Application number: 2022/90404	
What is the application for?:	Erection of three storey rear extension
Address of the site or building:	8, Ashbourne View, Cleckheaton, BD19 5JE
Postcode:	BD19 5JE

User comments

Proposed elevations

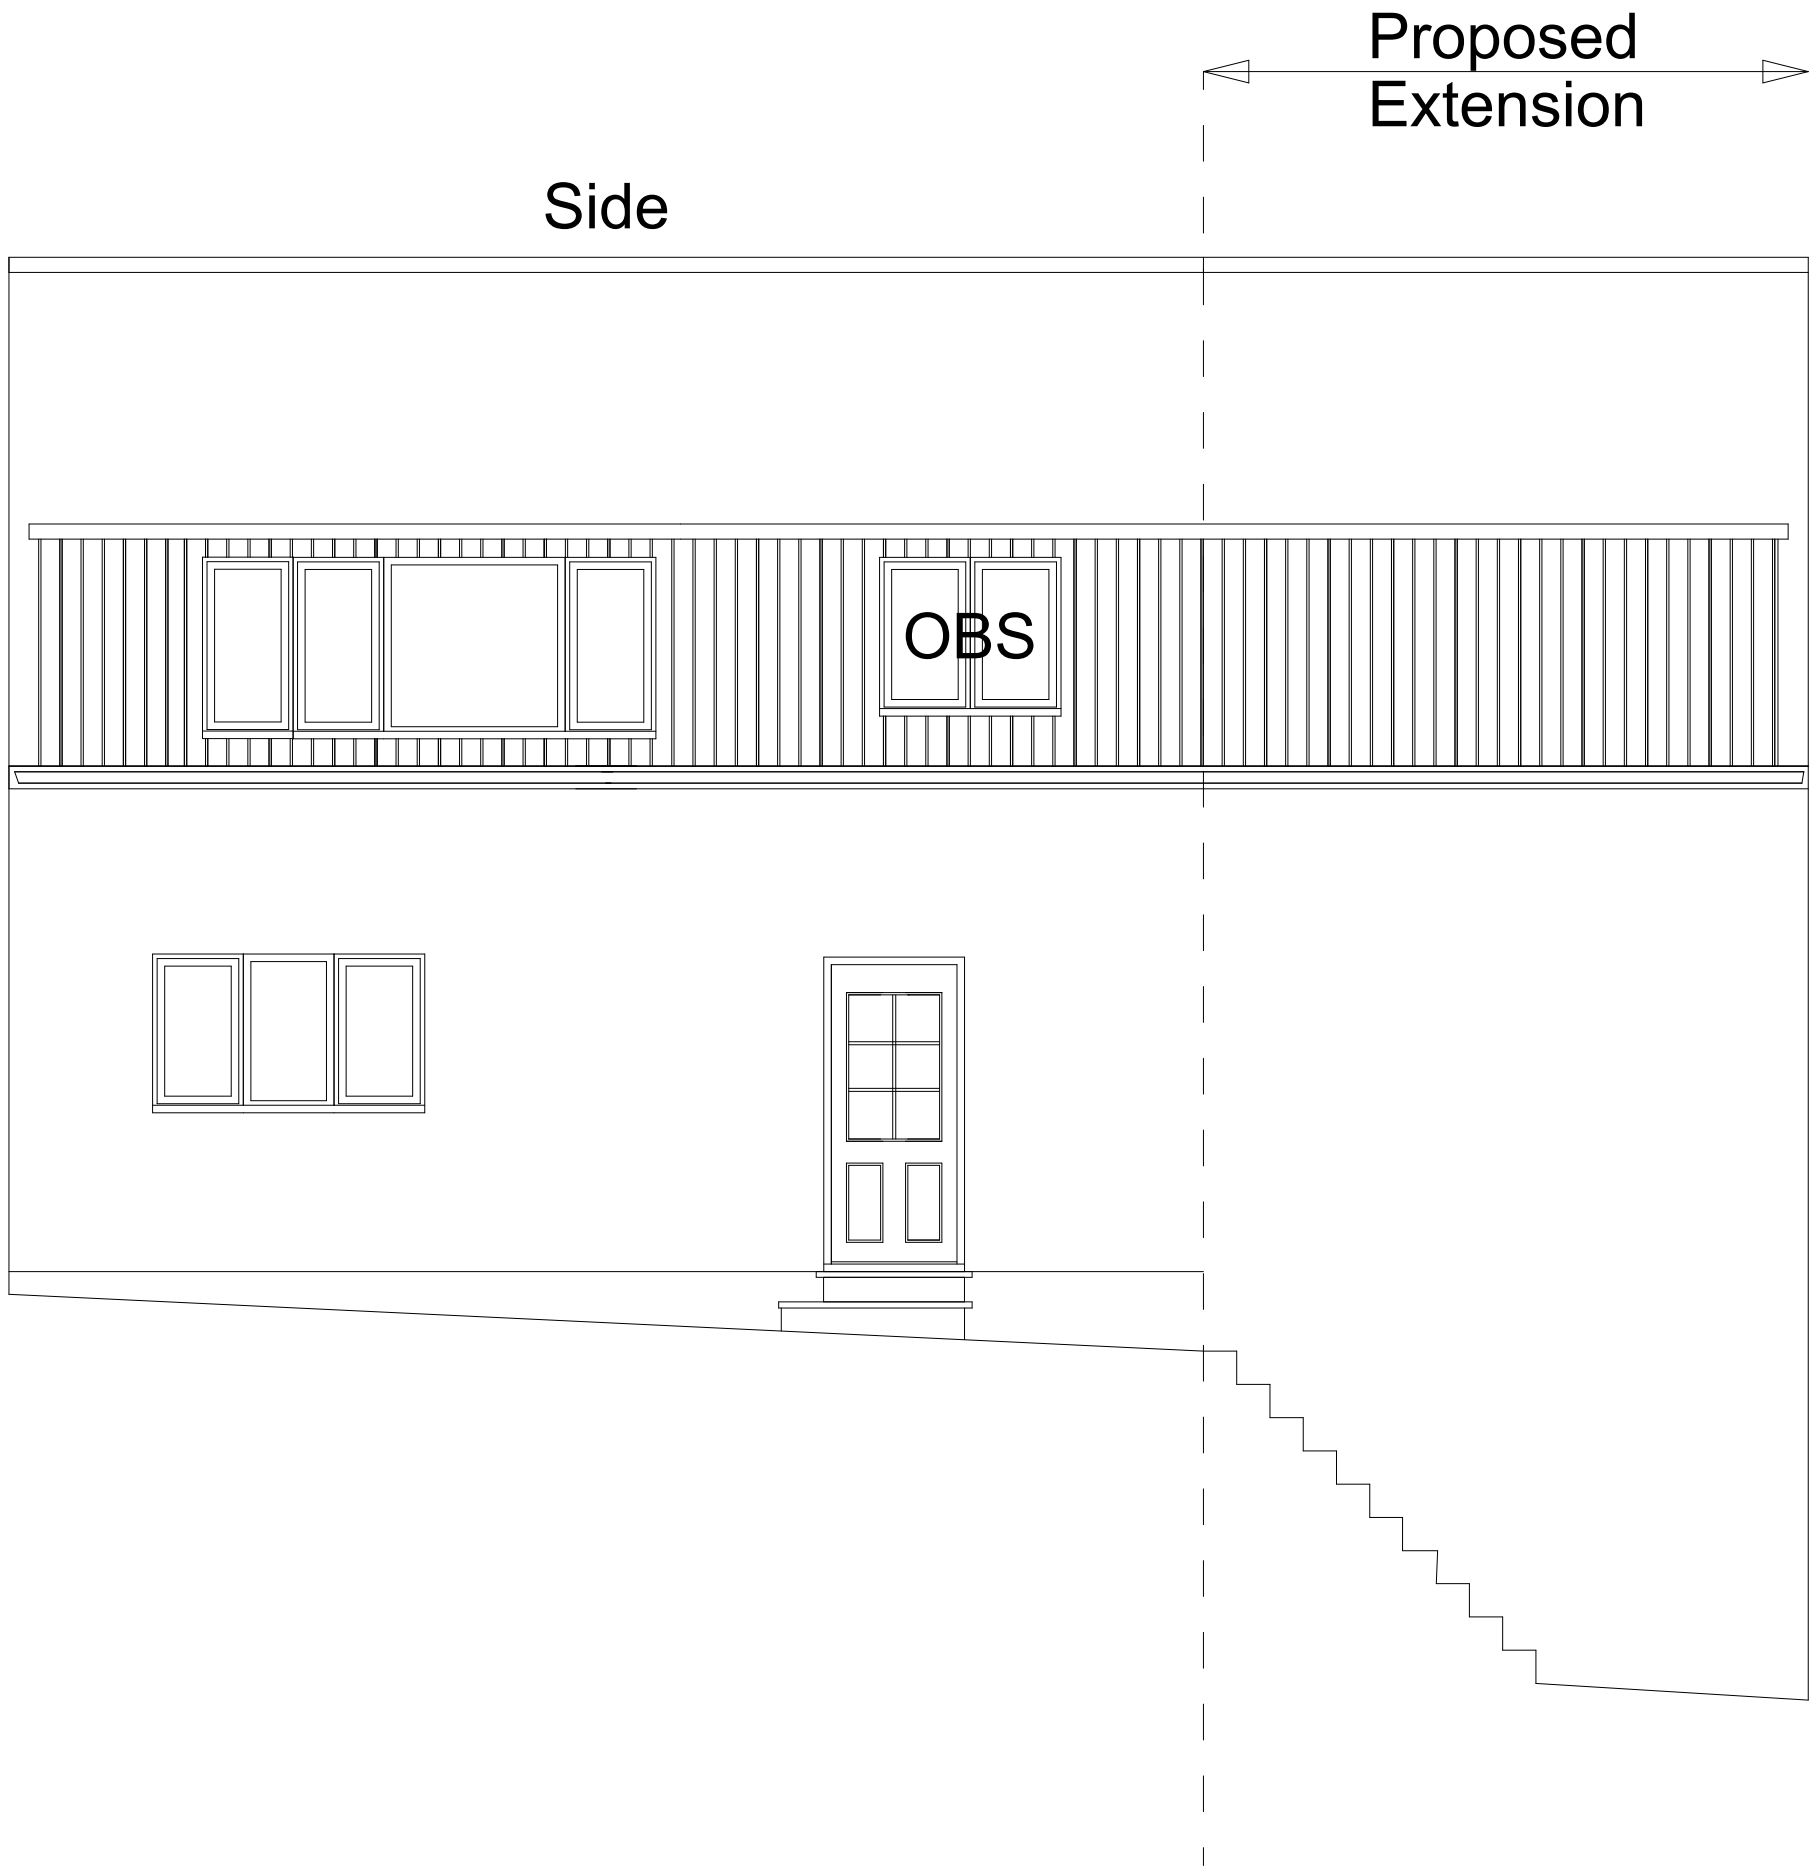
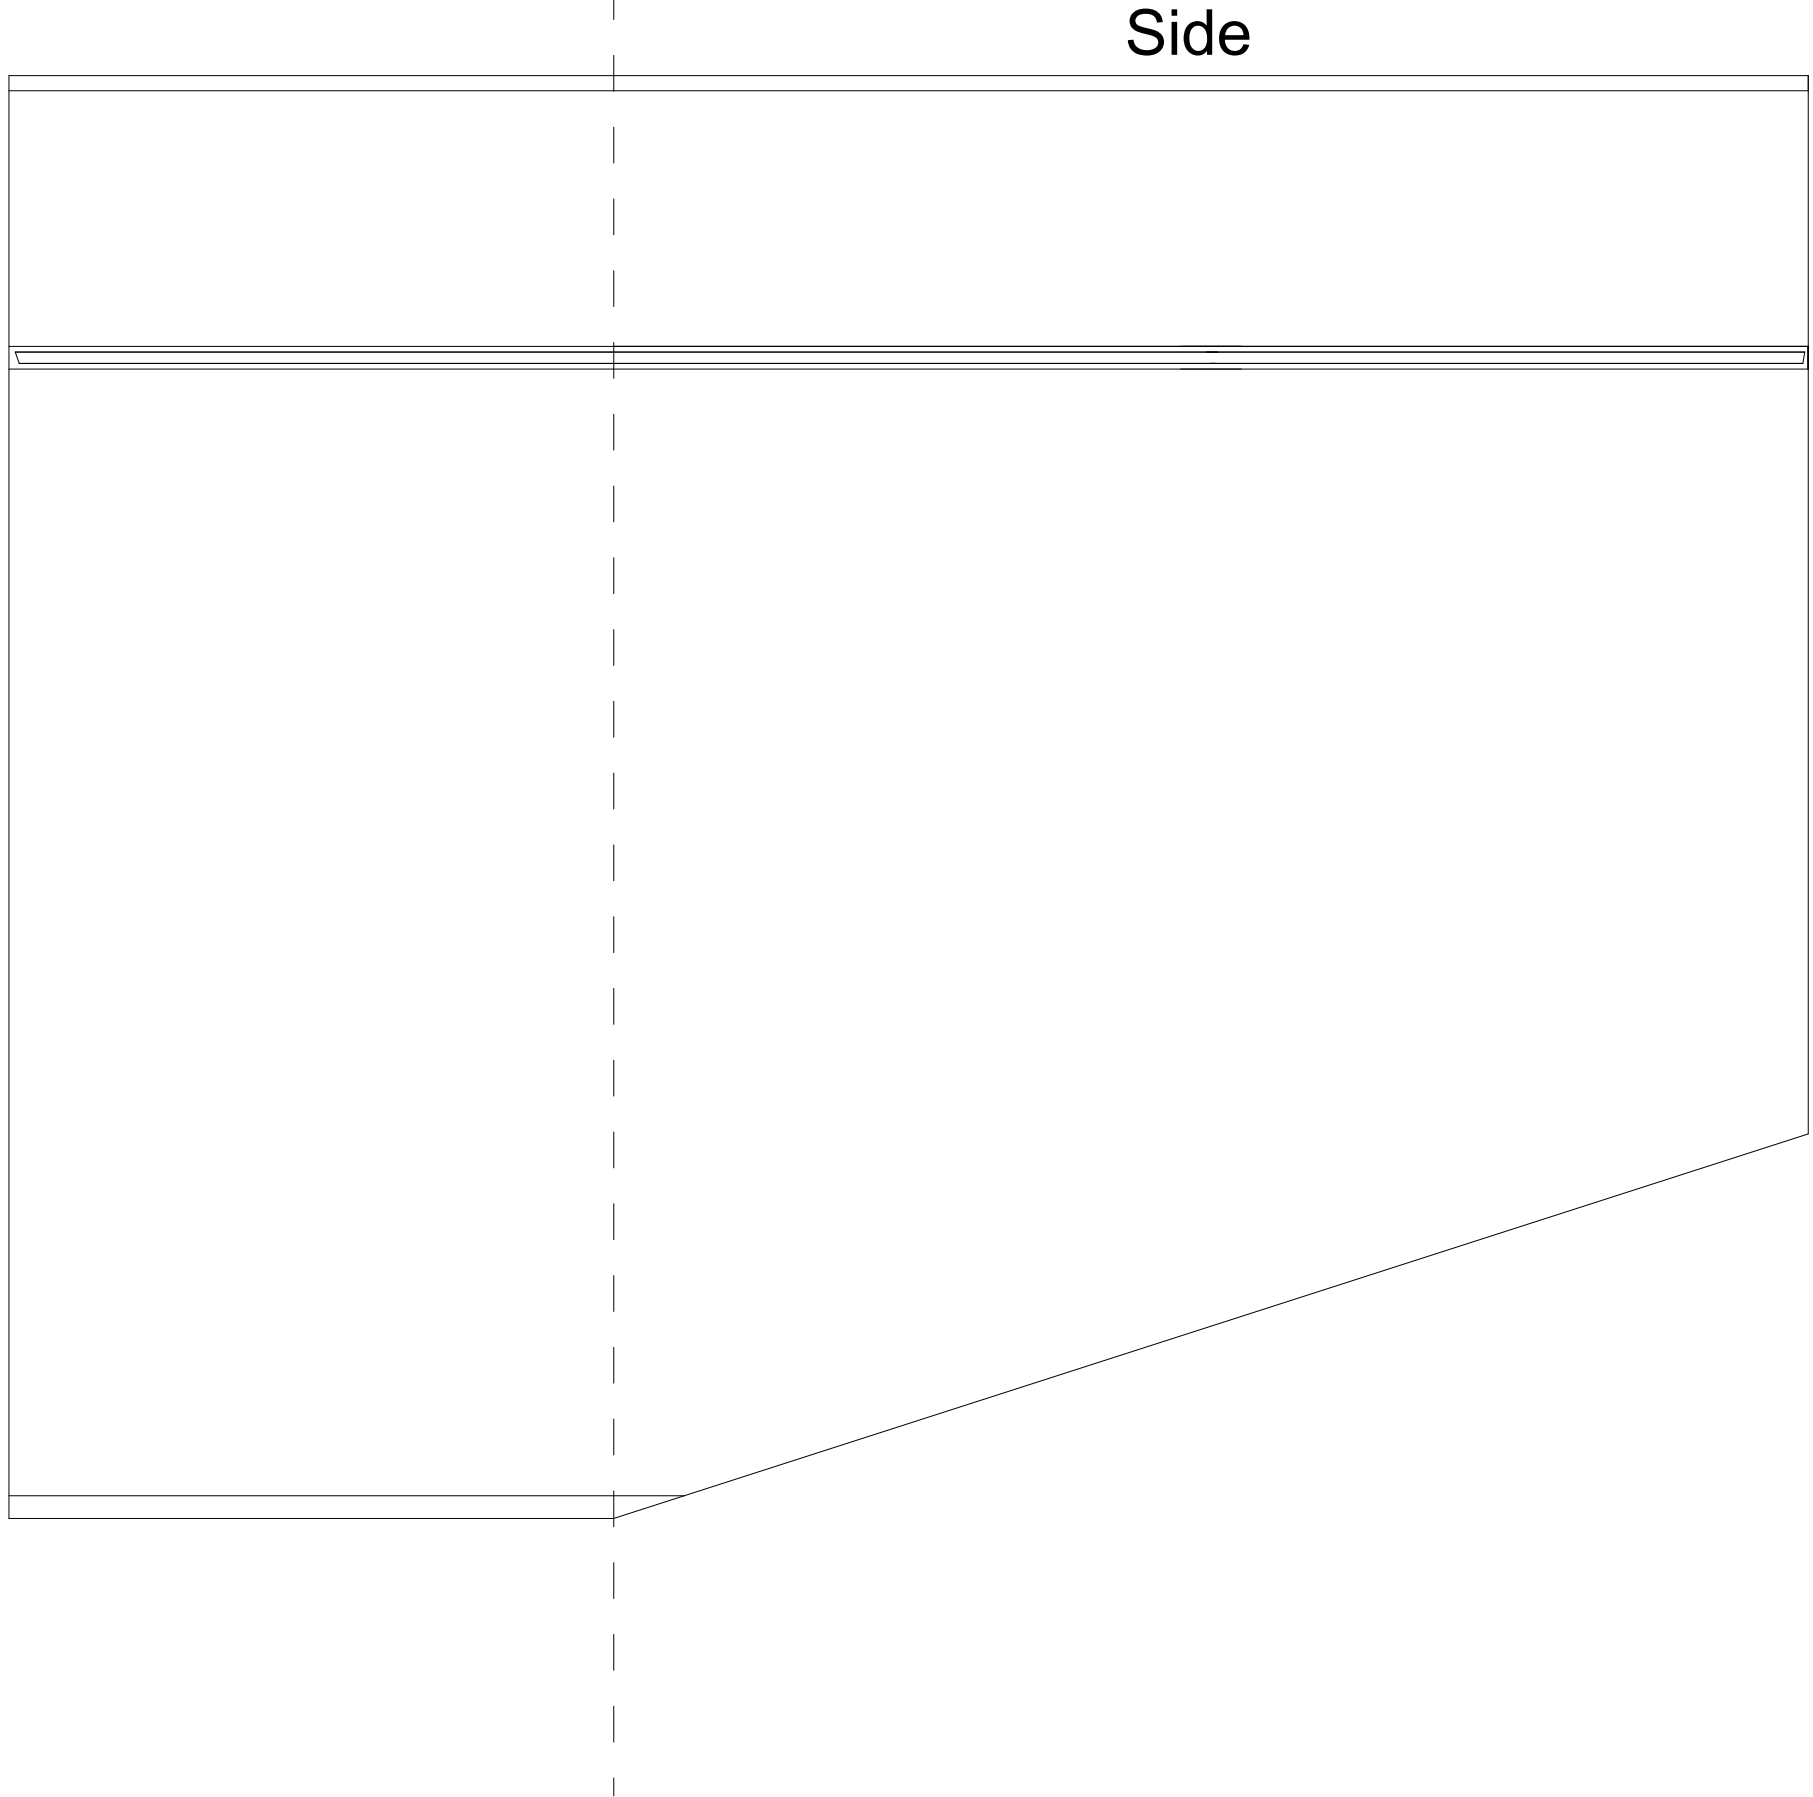
Type of comment: A general comment	
Do you wish your comments to be published on the website anonymously?	Yes
We are concerned over the impact the size of the extension will have on restricting the sunlight and daylight on our property and garden. As the extension is three storeys high this will have a greater impact than we feel is acceptable.
